Re: Wal-Mart at Lester and Wyoming, Development Application #, Project #PR-2021-005461/SI-2021-00680

Please find responses below in bold addressing the Transportation Development Comments received May 12, 2021.

SHEET:
CS1

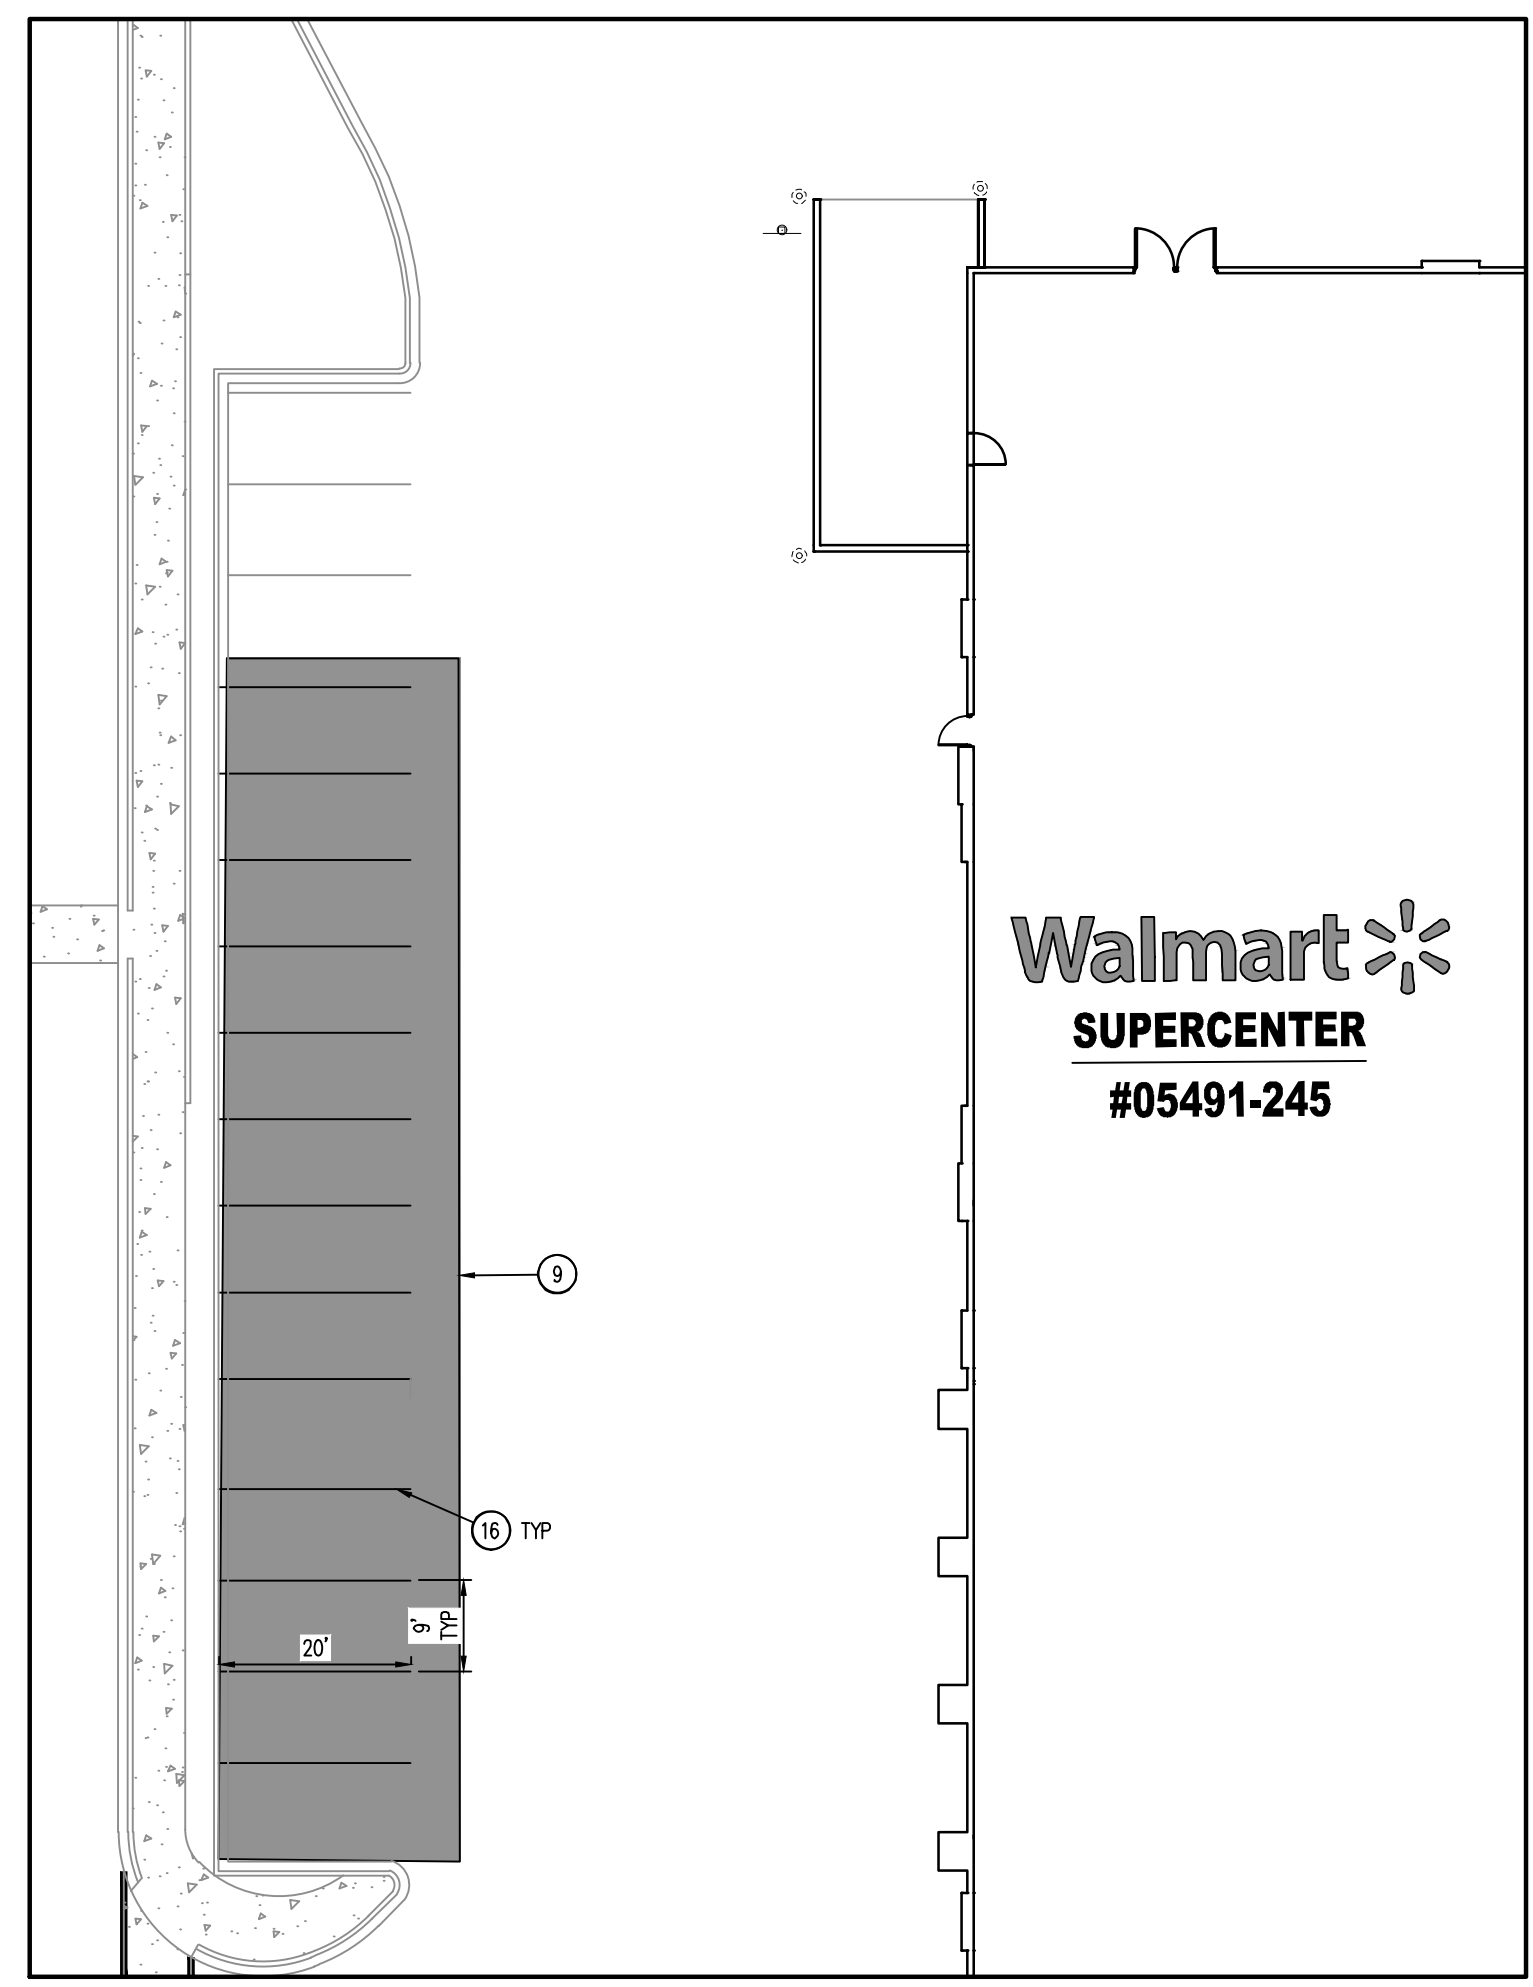
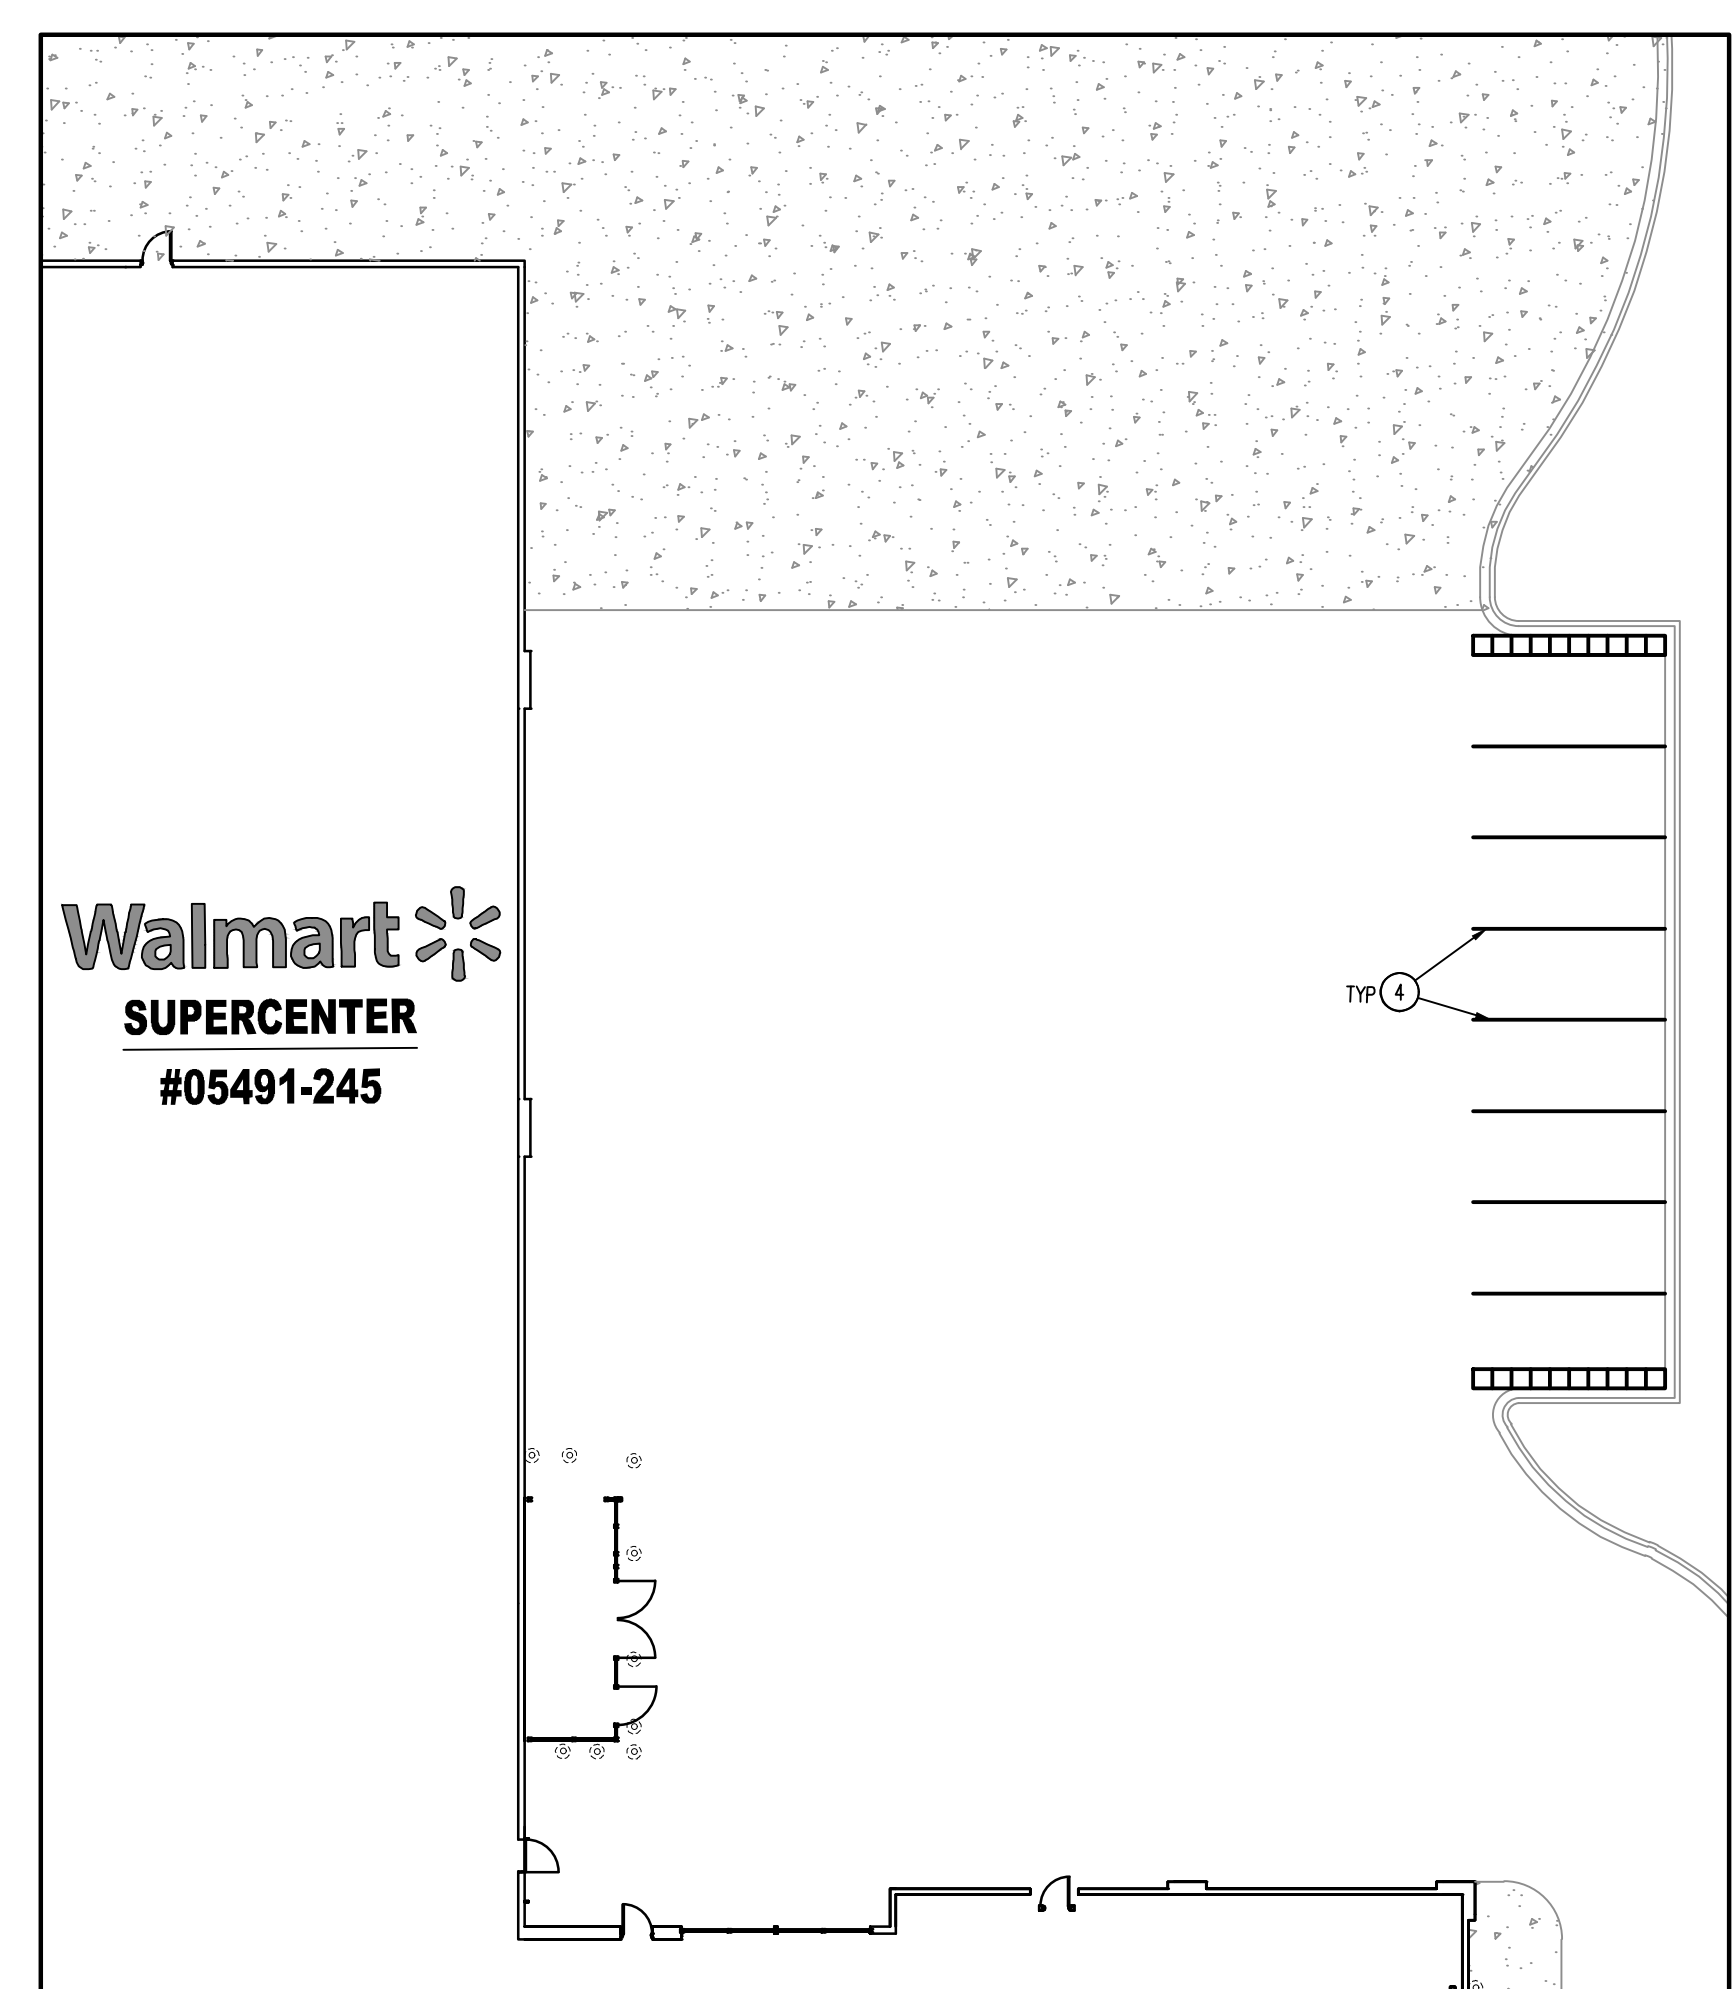
3. On the SECP-2 sheet, include dimensioning for the new pick-up spaces, crosswalks, driving aisles, etc.

Response: SECP-2 has been updated to included dimensions as indicated. In addition, plan sheets CS1, CS2 and CS3 have been added to the plan set. The requested details are also included on the CS1 plan sheet.
